2004-0202  
 Application I. D. Number  
 10/1/2004  
 Application Date  
 Hope Ave. Lot 12  
 Project Name/Description

Remarks:  
**Jay, as requested, attached is the revised grading plan for lot 12. The plan depicts the new finish floor elevations and the corresponding grading. The plan also shows the approximate location of the contours as generated by the owner/developer. The foundation drain has been revised to outlet to the rear of the property. Please call with any comments or questions.**

**From:** Jay Reynolds  
**To:** Doug Reynolds  
**Date:** Mon, Oct 18, 2004 4:33 PM  
**Subject:** PRP 3, Lot 12 comments

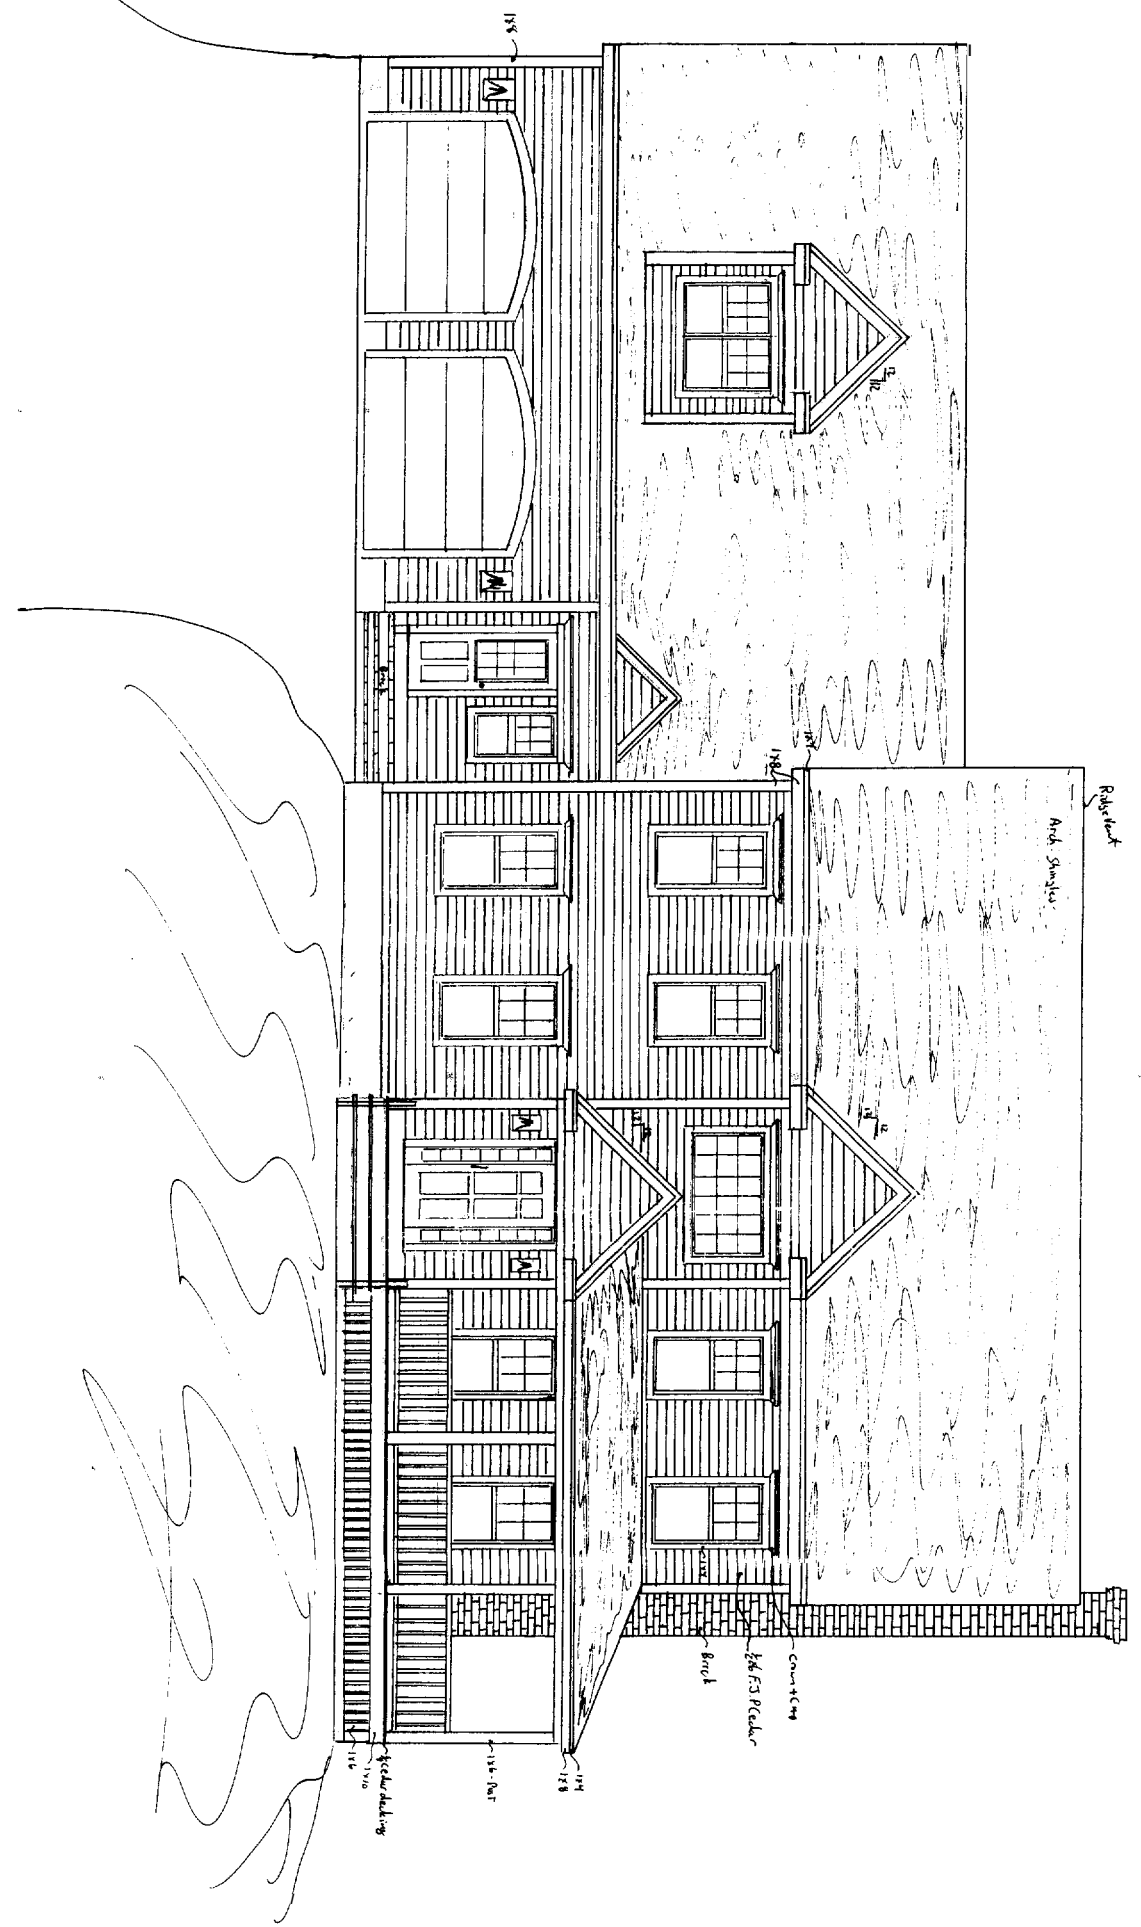
1. The lot has been cleared prior to issuance of a building permit and without written approval from the planning authority. A stop work order will be forthcoming to the applicant. You may want to alert your client to this.
2. Please remove 'snow fence' as an erosion control measure for wetland protection. This should be silt fence or E.C. mix.
3. Move Foundation drain so that it discharges more towards the rear property line, as opposed to the side prop. line.
4. Curb cut location is OK, (varies from subdivision).
5. Sewer lead is OK with insulation installed correctly (as noted).
6. Topo and FFE is OK. If the owner would like to amend this, I'd entertain this. However, the proposal should be based on actual existing topography. The only concern I see is steep sideslopes behind/beside the garage.
